**WELWYN HATFIELD BOROUGH COUNCIL
EXECUTIVE DIRECTOR - PLANNING, PUBLIC PROTECTION AND GOVERNANCE**

DELEGATED APPLICATION

Application No: 6/2020/1325/FULL
Location: Land Adjacent to 48 The Ridgeway, Cuffley, Potters Bar, EN6 4BA
Proposal: Erection of detached dwelling and new vehicular access
Officer: Mr David Elmore

6/2020/1325/FULL

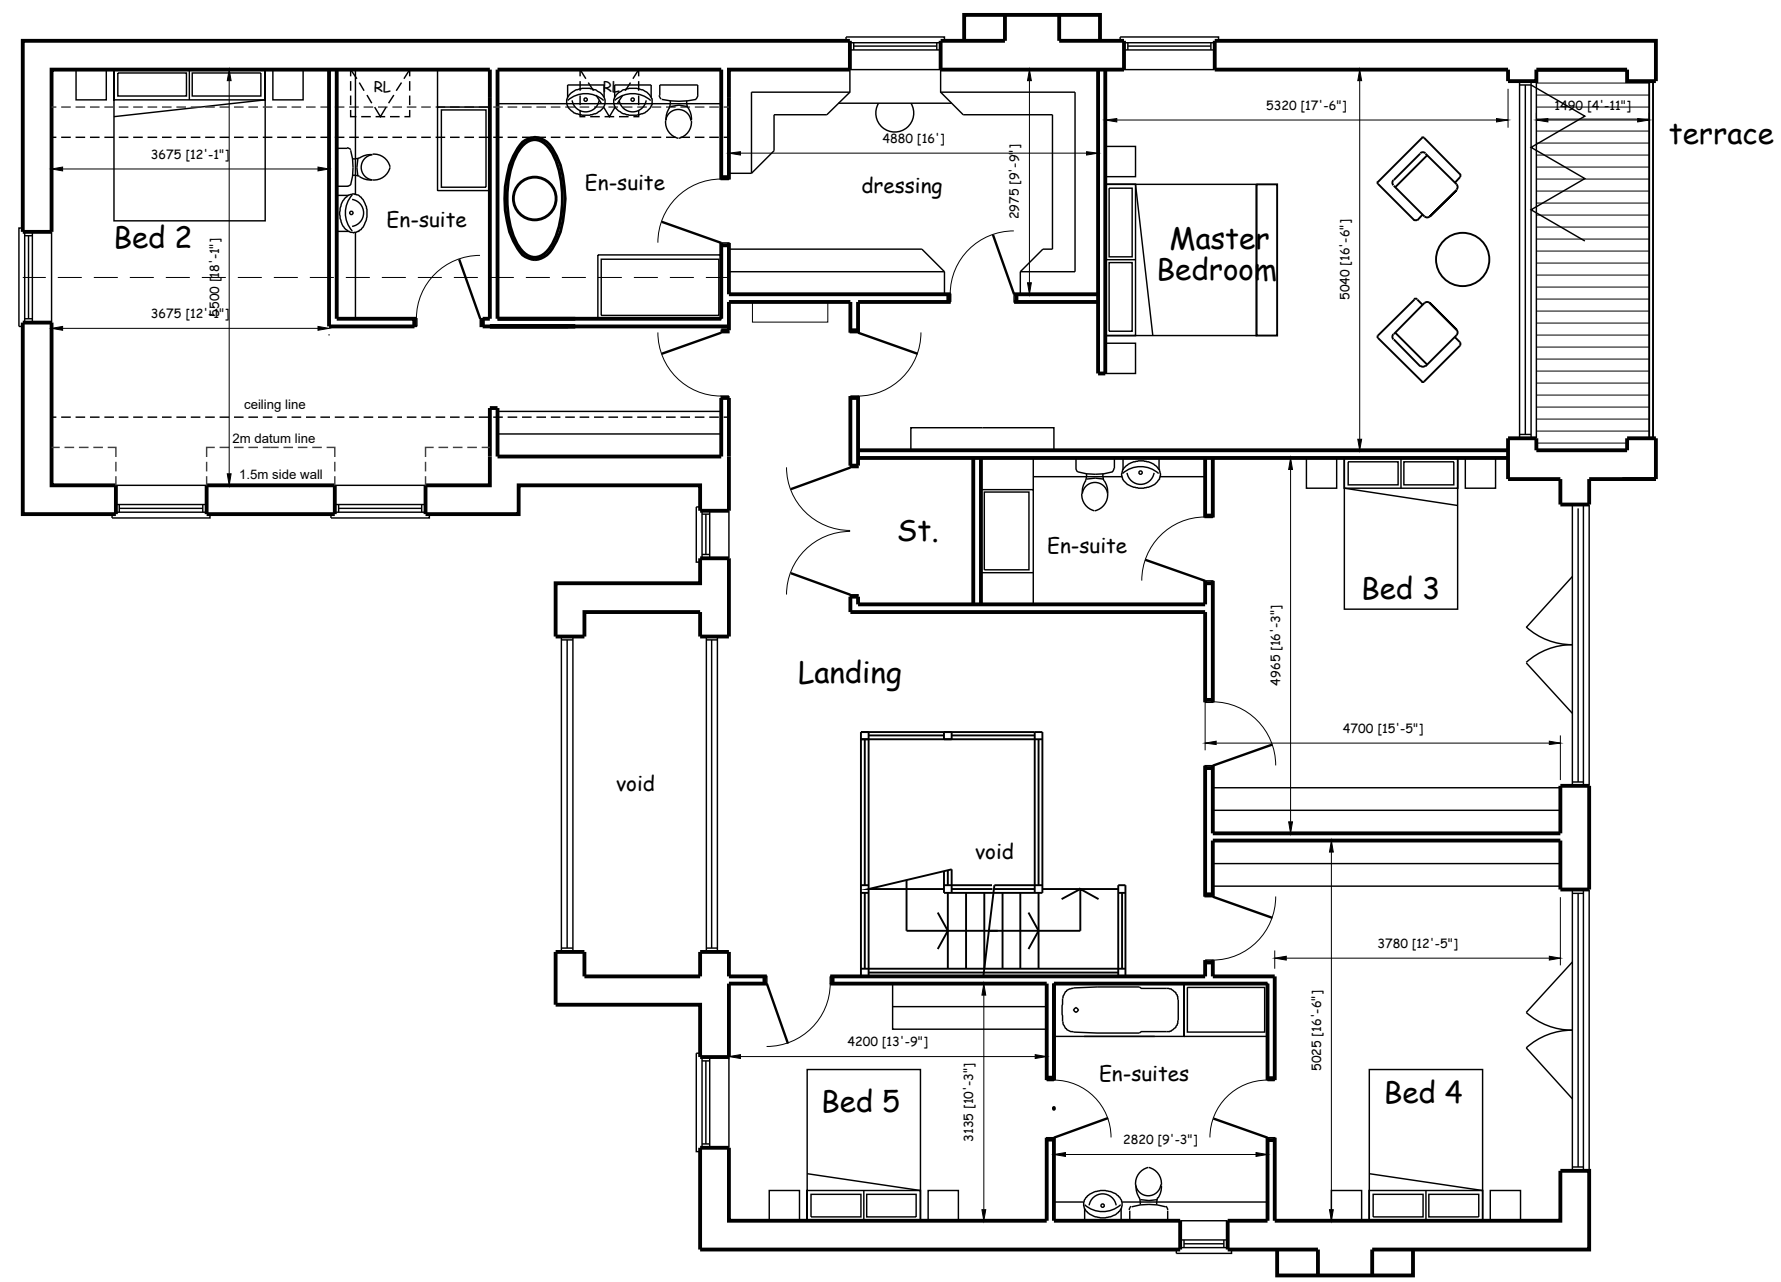
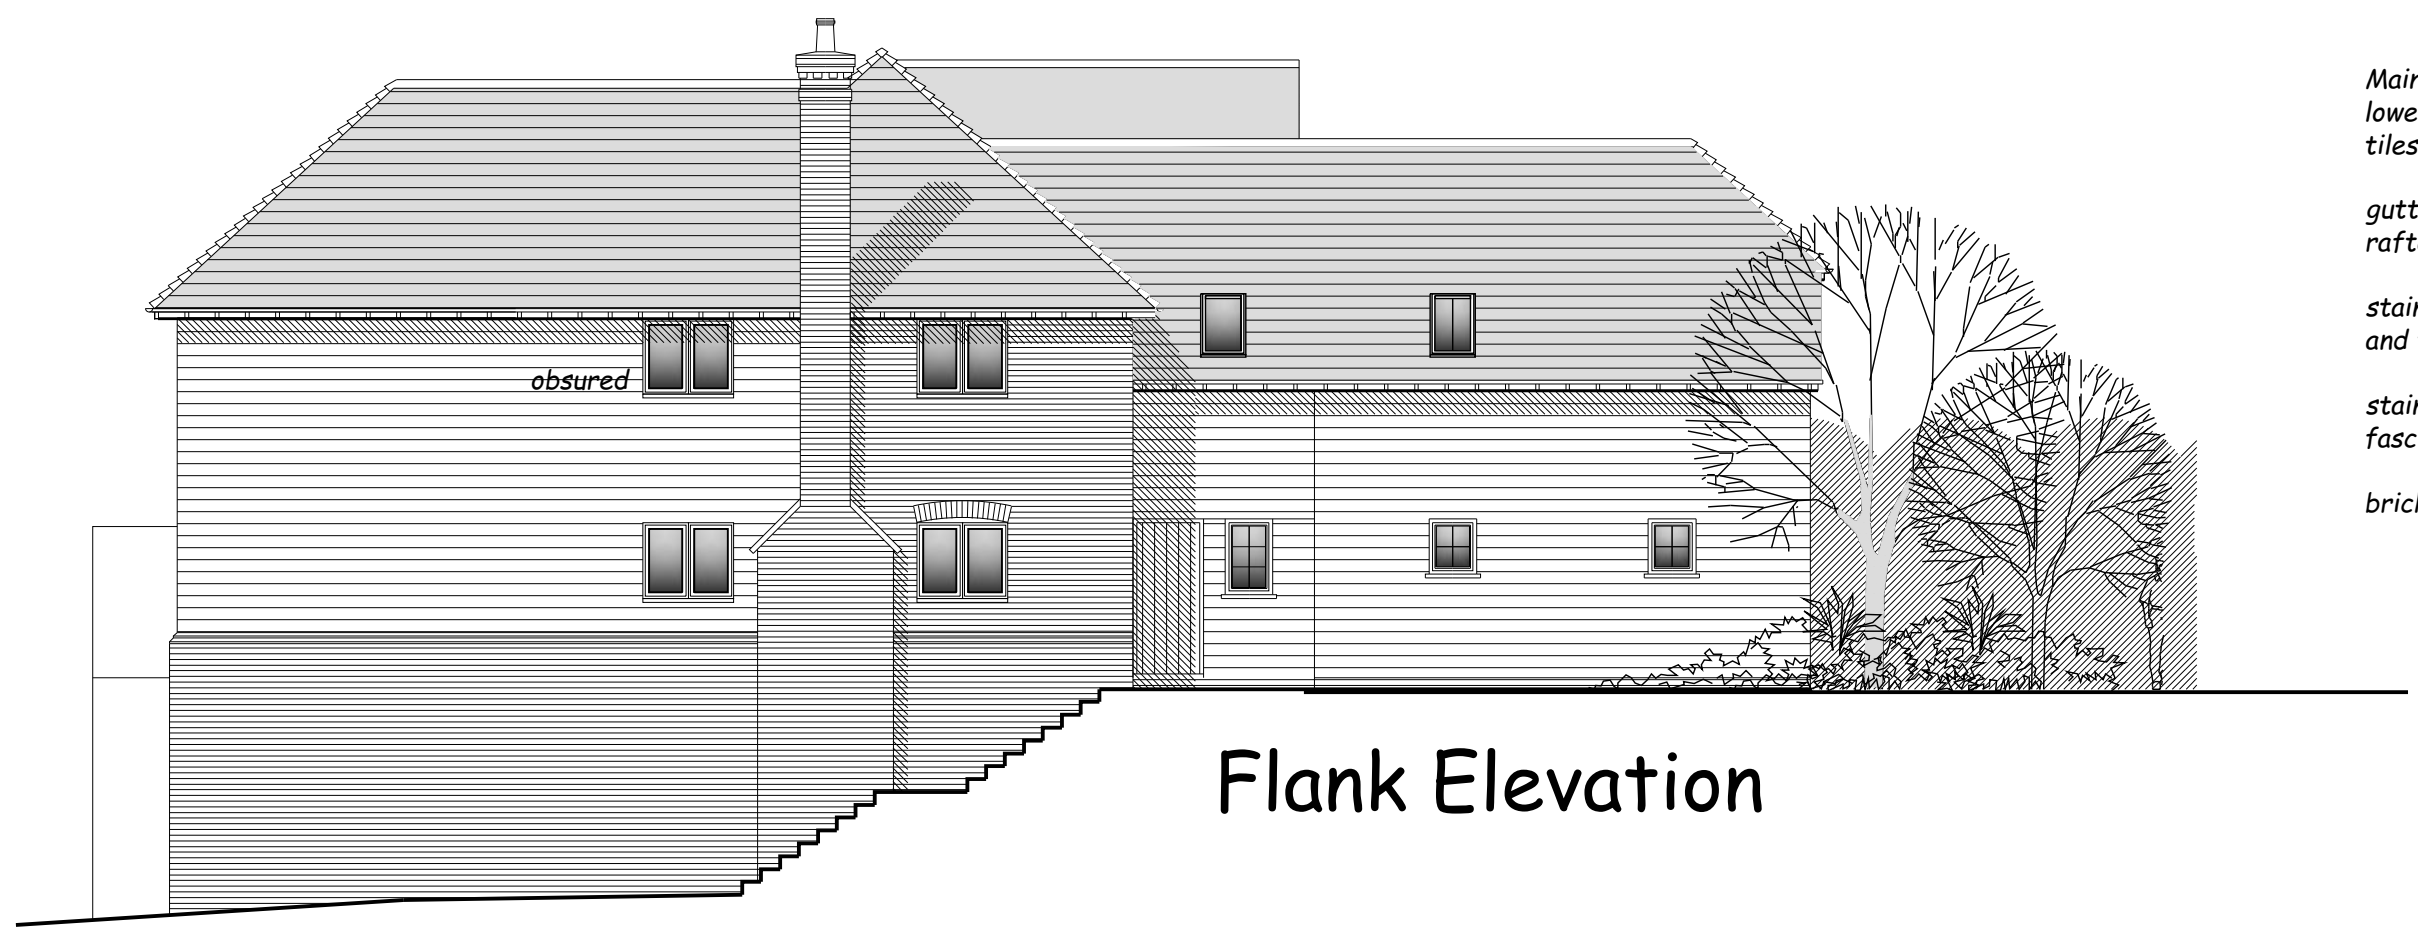
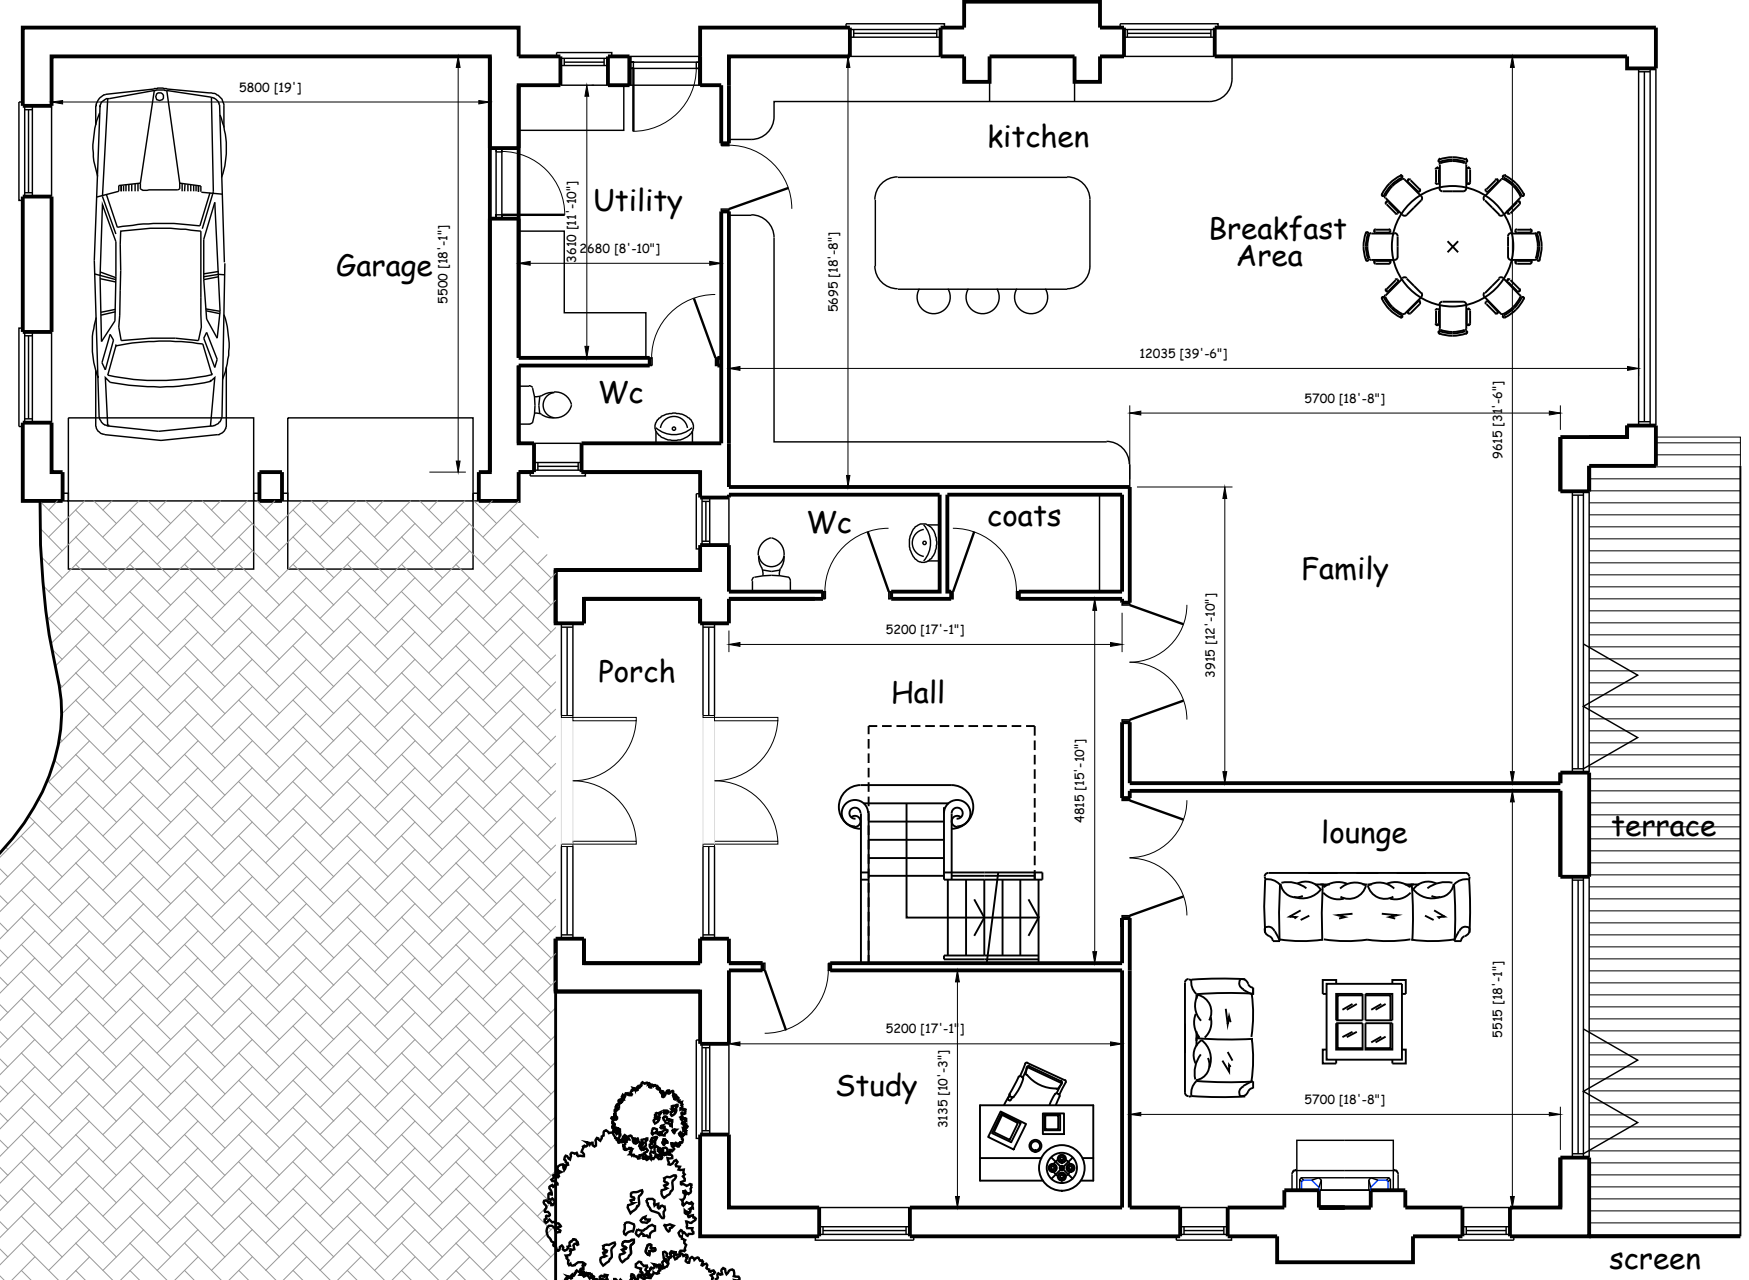
The dwelling would be faced in a mix of timber boarding and brickwork below a natural slate tile roof. Having regard to the variety of materials used on dwellings in the area, the principle of the proposed materials are acceptable. The use of timber boarding in the background behind retained boundary landscaping would further make the dwelling and its size less apparent.

Upper floor side facing windows (serving bedroom, dressing room, en-suites) would face flank windows of the two neighbouring properties on either side. All these windows (save for the dormer windows) give rise to potential for overlooking and loss of privacy. To prevent such adverse effects, it is considered necessary and reasonable for these windows should obscure glazed with a restricted level of opening. This measure can be secured through planning condition.

5. The upper floor side windows of the dwelling hereby approved (excluding dormer windows and rooflights) must be obscure glazed; and non-opening (unless the parts of the window which can be opened are more than 1.7 metres above the floor of the room in which the window is installed), and shall be retained in that form thereafter.
